Subject: RE: 8 Fernhurst gardens.

Kathryn Welch
Planning Officer, Planning Department

Re-place existing sun room with purpose built ground floor extension with pitched tiled roof.
Double glazed windows and doors

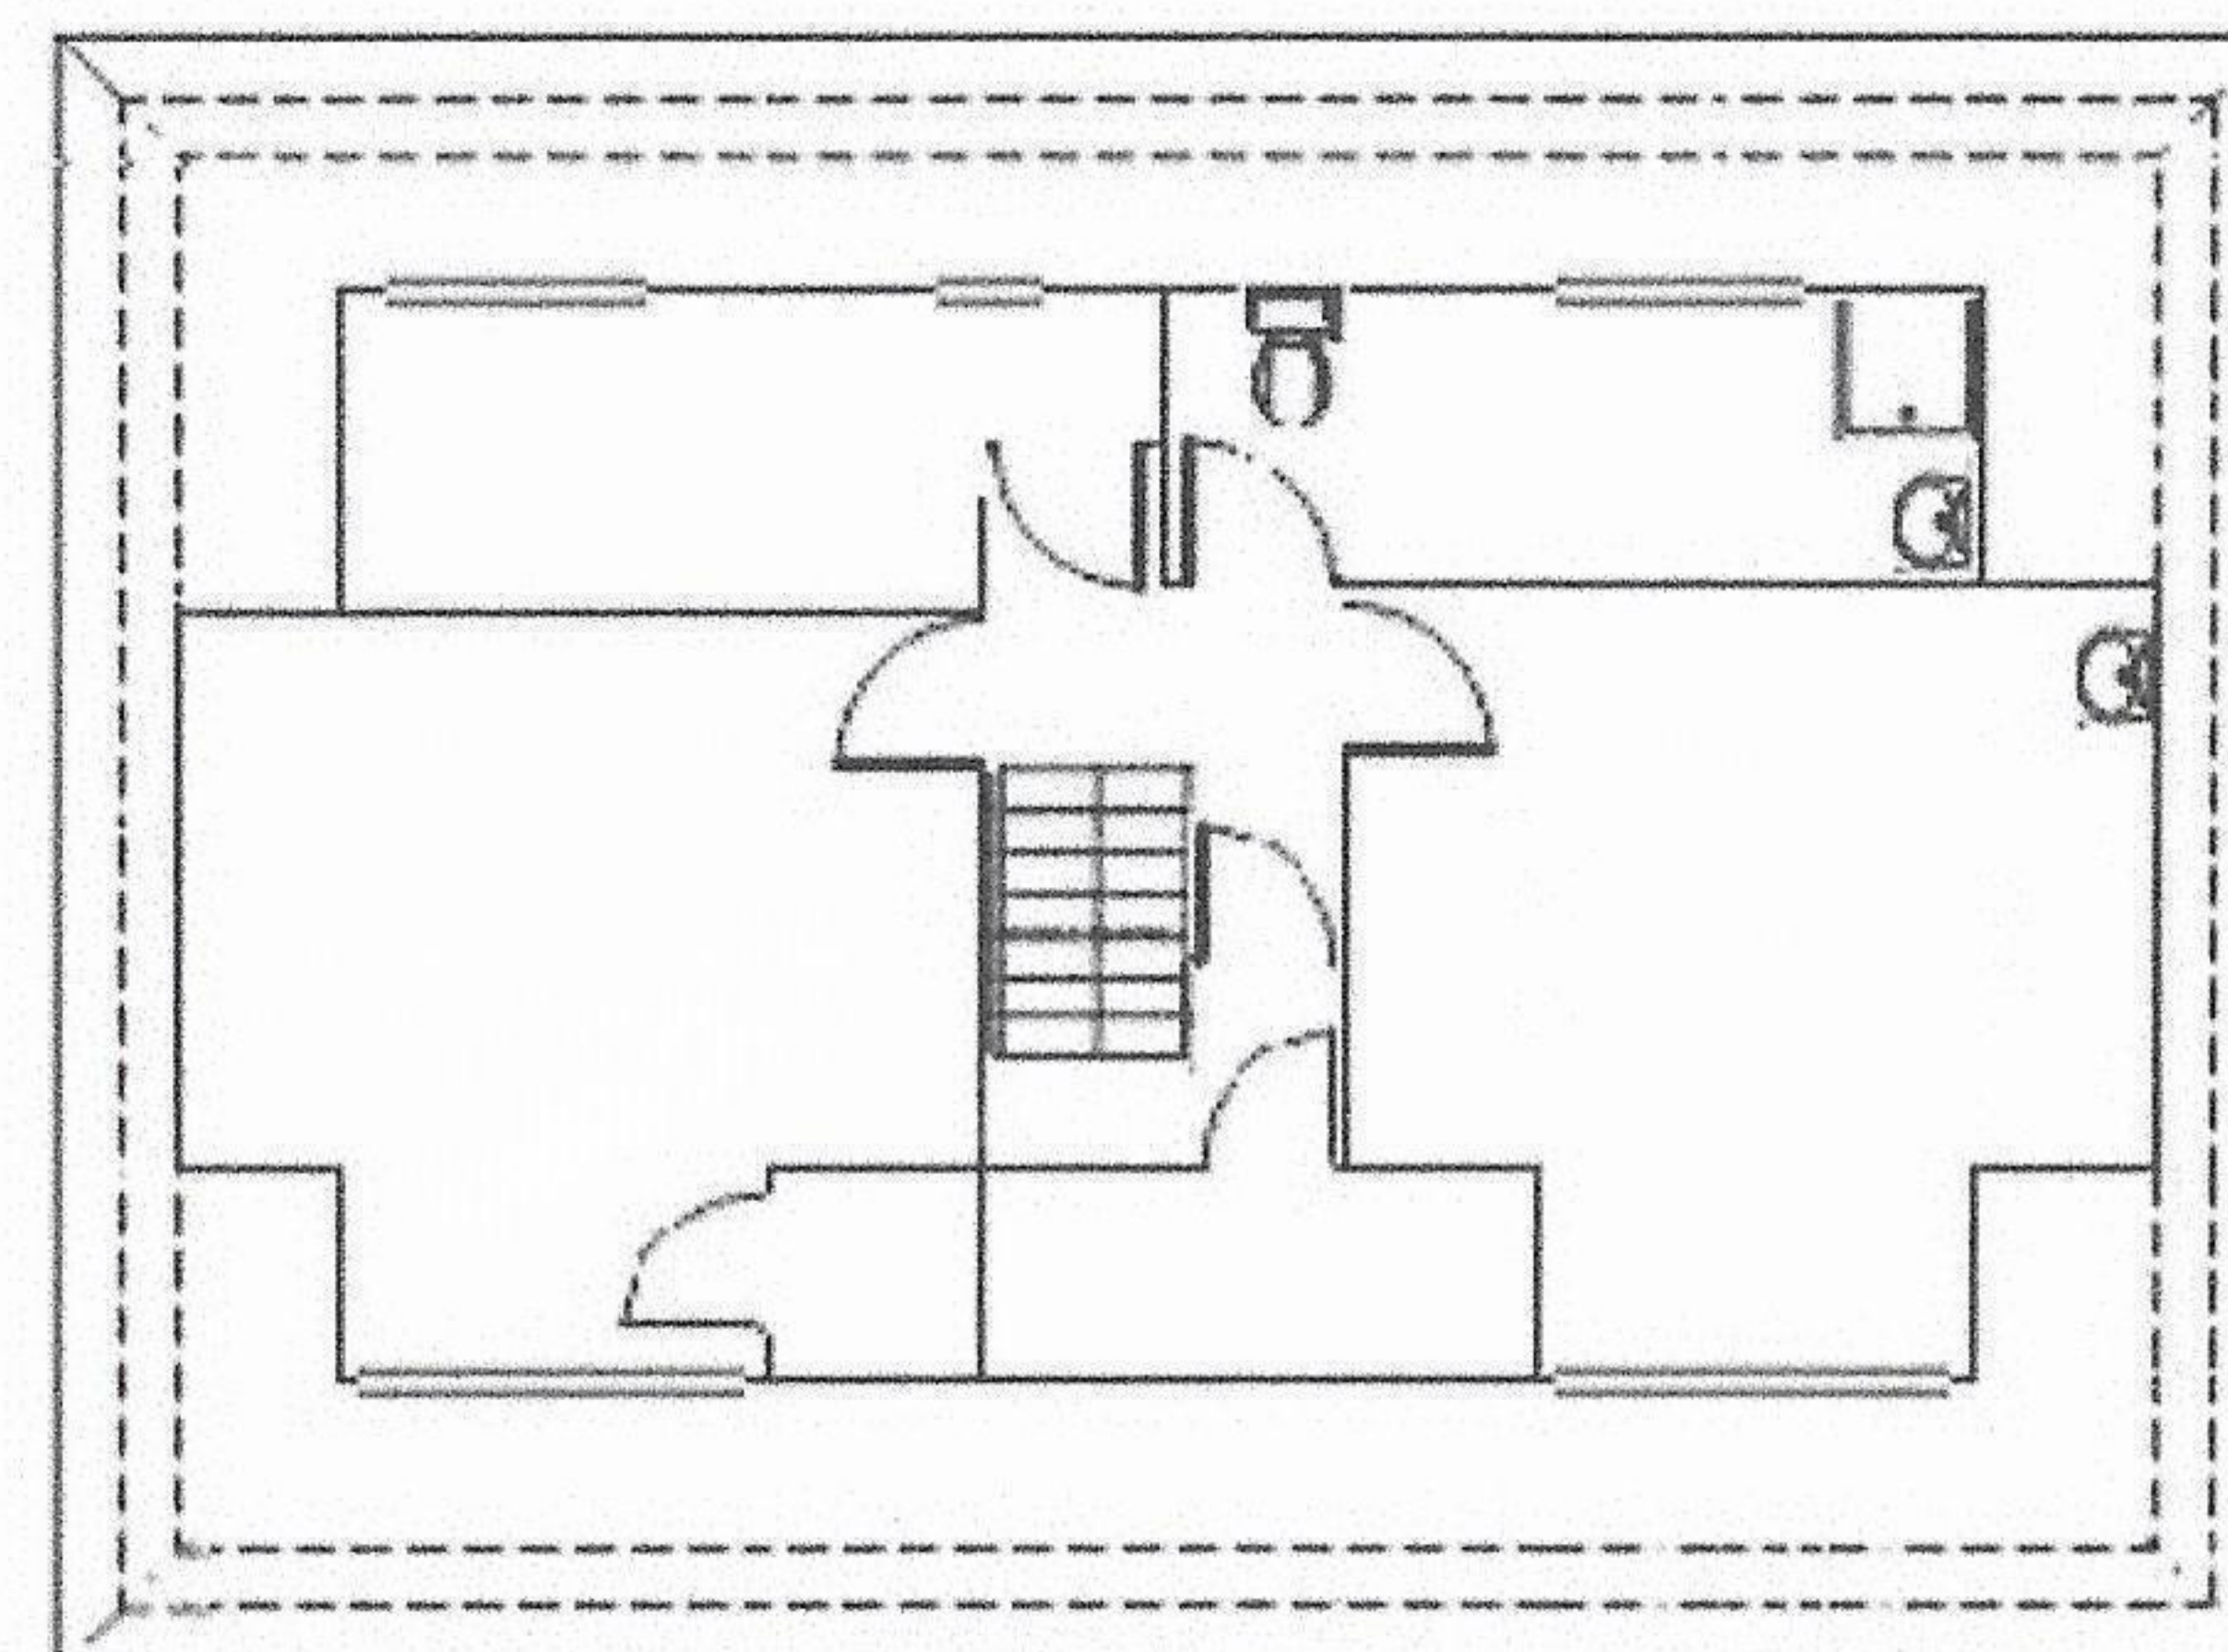
- The porch is slightly too large, to be covered by PD rights the maximum allowance is 3m² and your proposal currently measures at 3.84m² can you adjust this on plans 010 and 003.
- Can I have confirmation of the height to the eaves for the extension, either via email or included within a plan,
- Can you confirm that the extensions will be built of materials to match the existing property. You've noted a concrete slate tile on the roof of the extension; do you already have these on the existing house or can you amend to something similar to the existing,
- Can you confirm the proposed hardstanding for 2-3 cars will be built of either porous materials or will drain off to water permeable area within the site, again just a written confirmation will suffice.
